Recommendation Report for Planning Permission**REF NO:** EP/42/17/PL**LOCATION:** Public Conveniences
Sea Road
East Preston**PROPOSAL:** Alterations to existing public conveniences including provision of disabled facilities & ramped access to toilet.**SITE AND SURROUNDINGS****DESCRIPTION OF APPLICATION**

Client: East Preston Parish Council	
Project Address: Toilets Sea Road East Preston	
Drawing Title: Existing and Proposed Plans and Elevations	
Drawing Number: 1059.01.e	
Scale:	As stated printed @ A1
Date:	14/10/2016

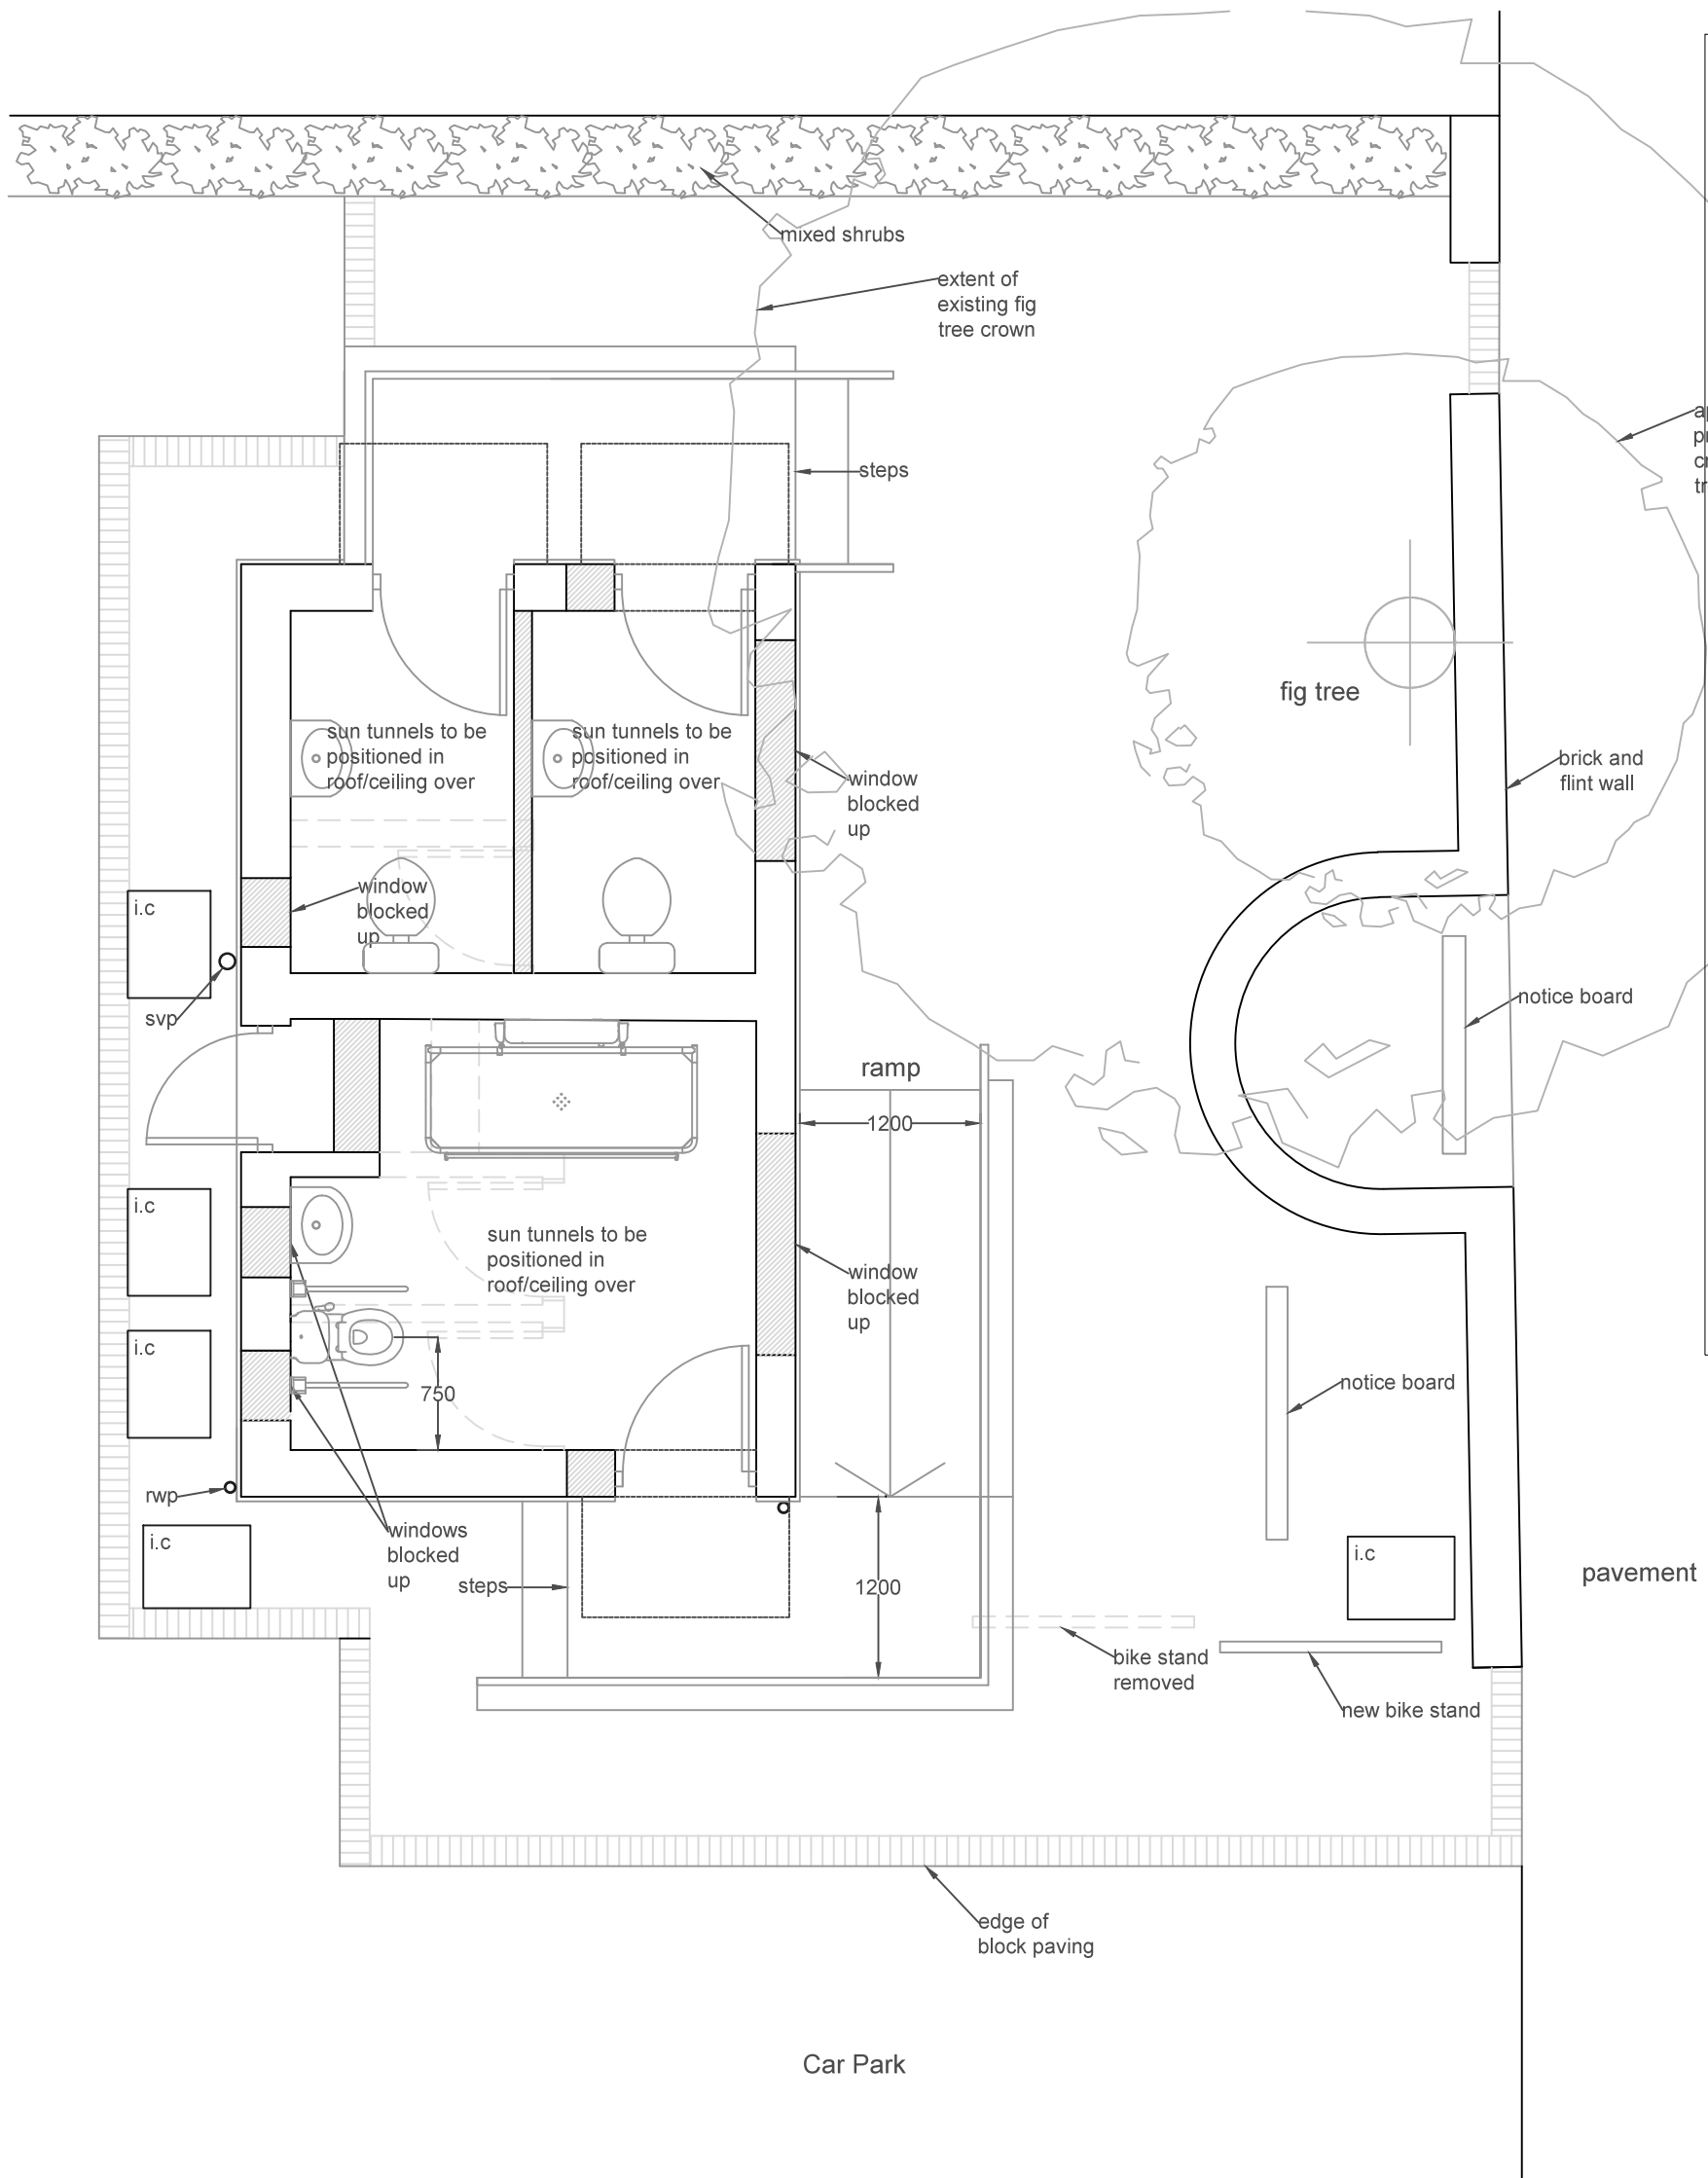
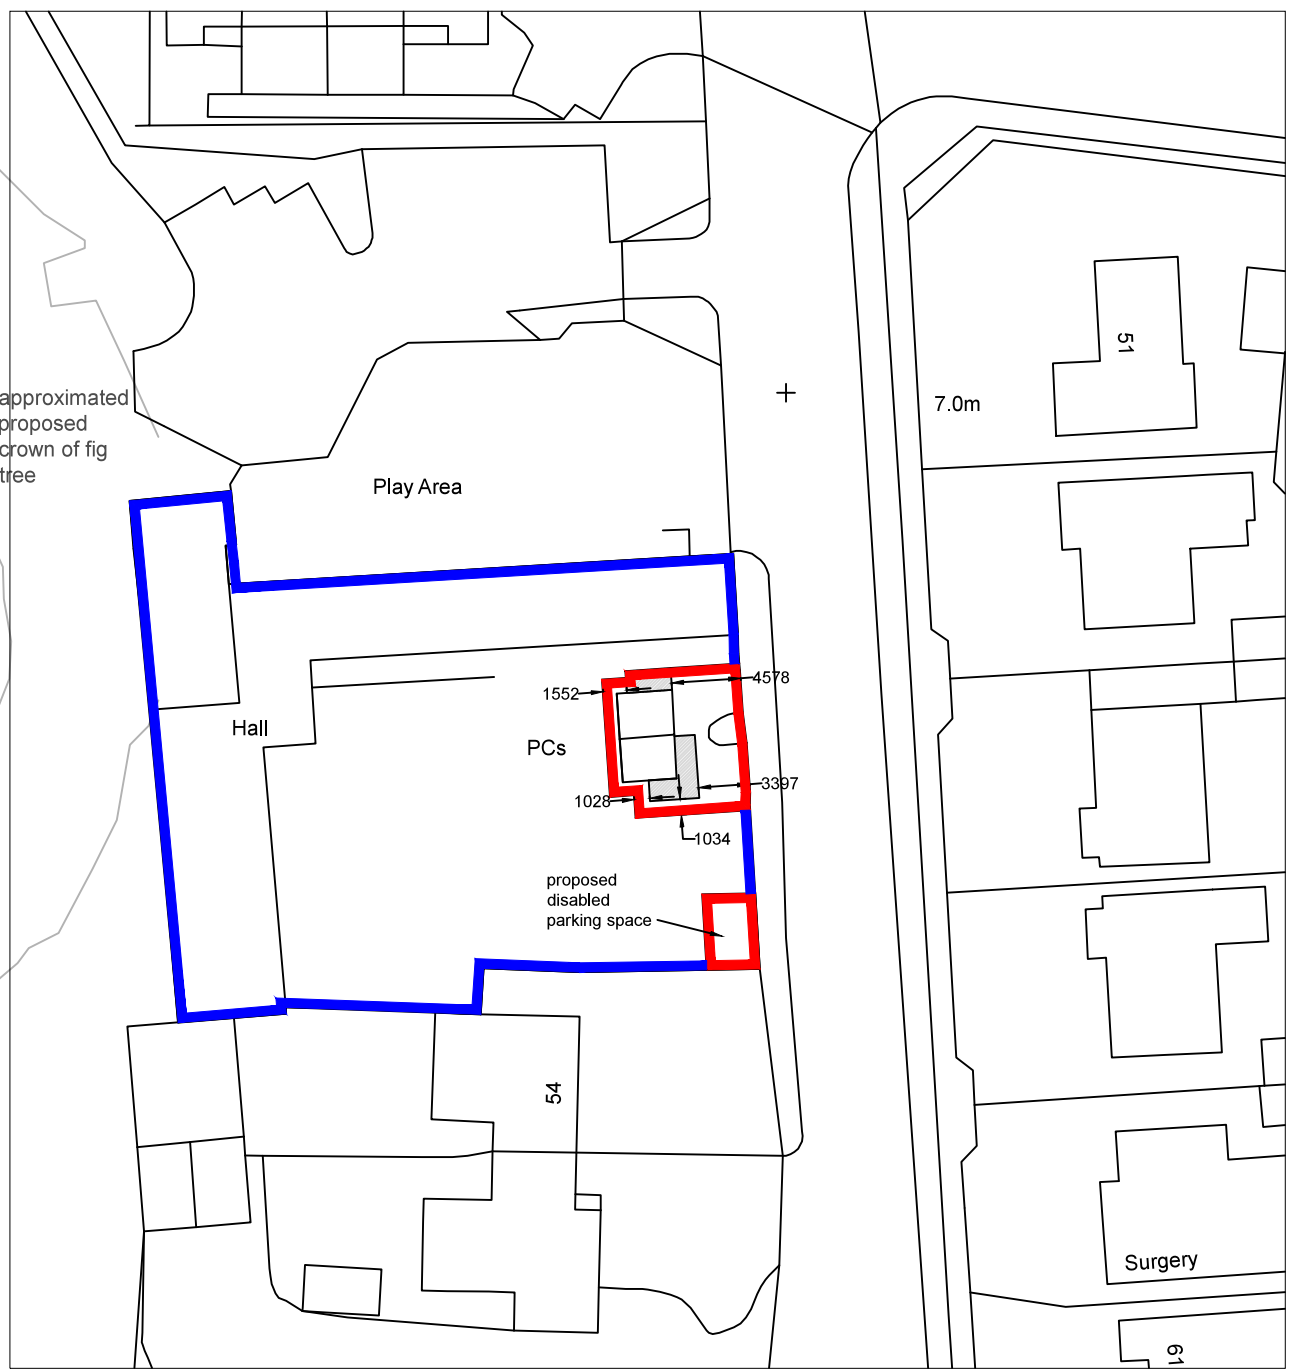
2 No Objection - Welcome proposal. Object to felling of fig tree which is a valued element in the street scene. The expert's report does not recommend felling. Cycle parking is being

removed, but can't see it being replaced.

- Felling because of the new ramp is not necessary because with the involvement of an Arb Expert they could have supervised 'Hand Digging' below the existing hard surfacing and severance of any roots found that are 25mm or less in diameter - at 4m distance from the centre of the trunk I would not expect there to be many roots over this diameter- if any.

- the tree should be retained and managed with pruning works.
- However, if planners see fit to approve the removal as part of the redevelopment works then I would like to see one quality semi-mature replacement tree planted in its place - of a species to be agreed.
- The applicants show two new Bay Laurel trees being planted which in my opinion would not be suitable and would not adequately mitigate the loss of amenity value provided by the Fig.

The concerns regarding the loss of the tree have been addressed in the amended plans which indicate that the tree is to be retained. The plans have also been amended to retain the bike stand.

- comments noted. It is now proposed that the fig tree will be retained.

The proposals did include removal of the fig tree and bike stand, but it has now been confirmed that the tree will be retained and the bike stand relocated drawings have been amended to reflect this. The retention of the tree would further enhance the visual amenities of the locality and retain an important feature in the locality. The replacement of the bike stand would also retain facilities to encourage sustainable modes of transport.
